Addendum No. 1

RE: Contract # C203876
WBS # 38455.3.1
STATE FUNDED
Wake County (B-4655)
Bridge #277 Over Black Creek On SR-1006

March 21, 2017 Letting

TOTAL BILL OF MATERIAL

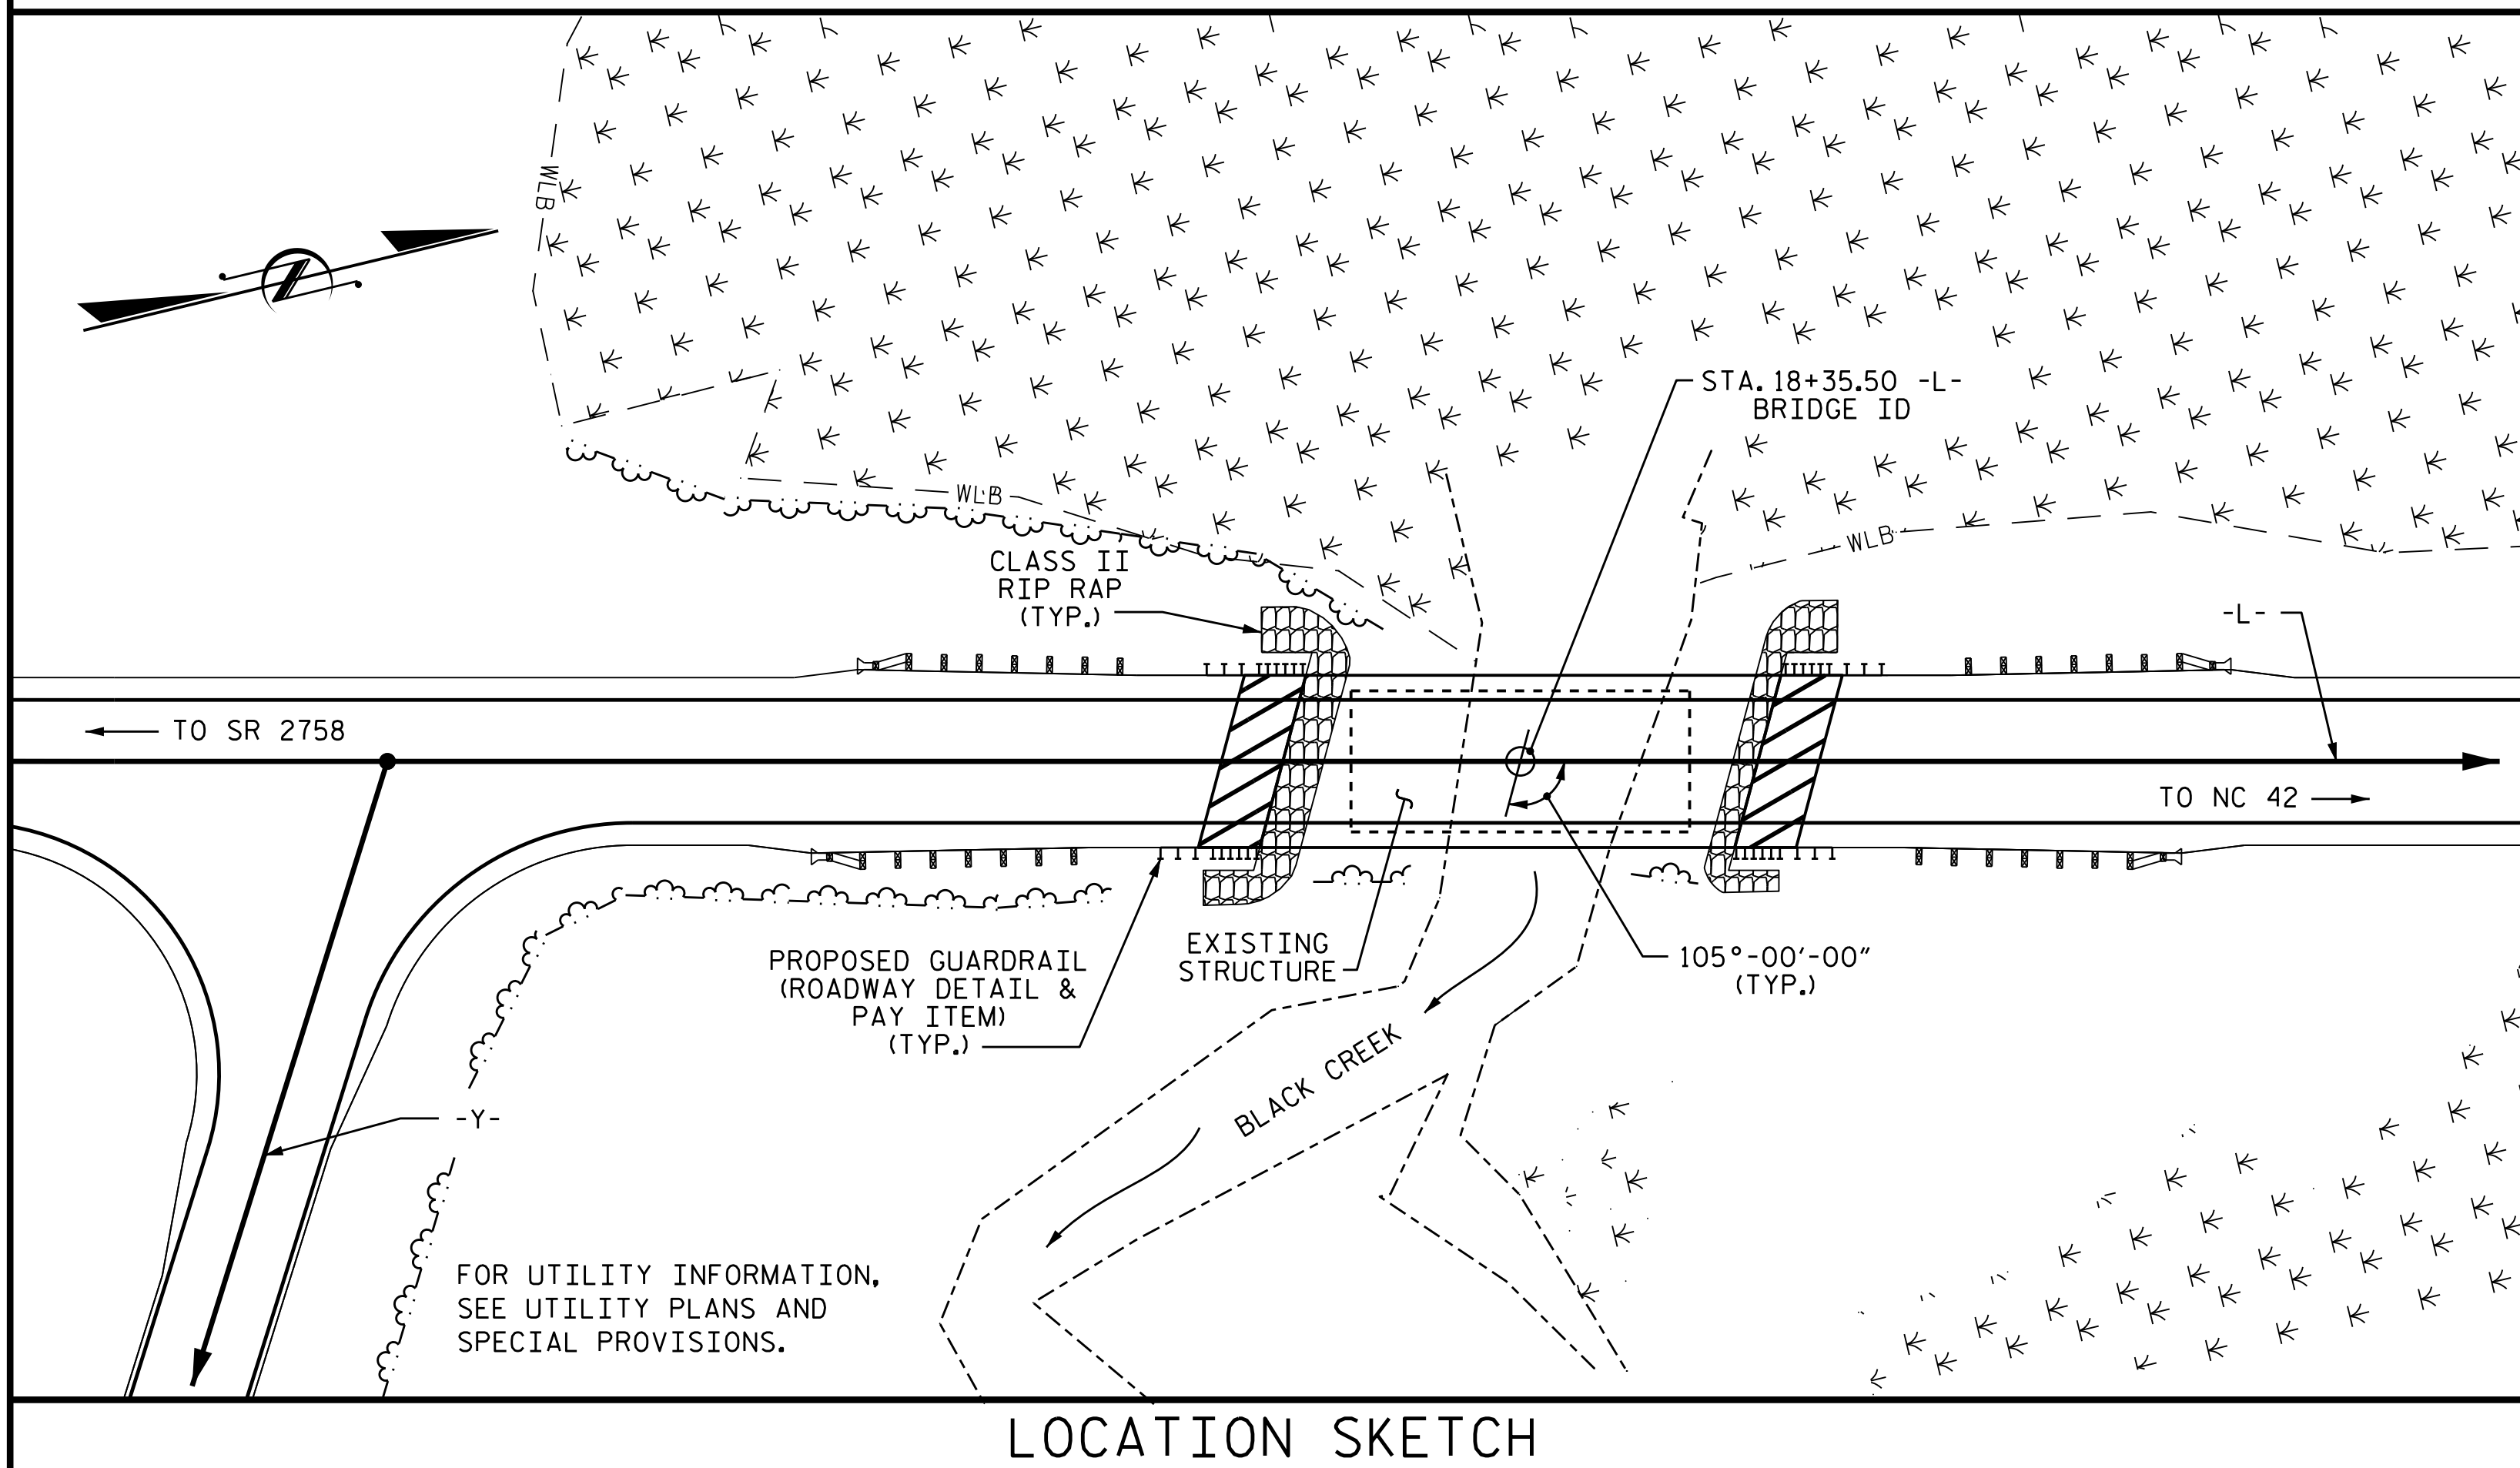
Sheet No.	Revisions
S-2	Corrected the beam depth for the Prestressed Concrete Box Beams within the "Total Bill Of Material"

<u>Item</u>	<u>Description</u>	<u>Old Quantity</u>	<u>New Quantity</u>
090-87532000000-E-430	3'-0" X 3'-3" Prestressed Concrete Box Beams	935 LF	DELETED
090-87531000000-E-430	3'-0" X 2'-9" Prestressed Concrete Box Beams	NEW ITEM	935 LF
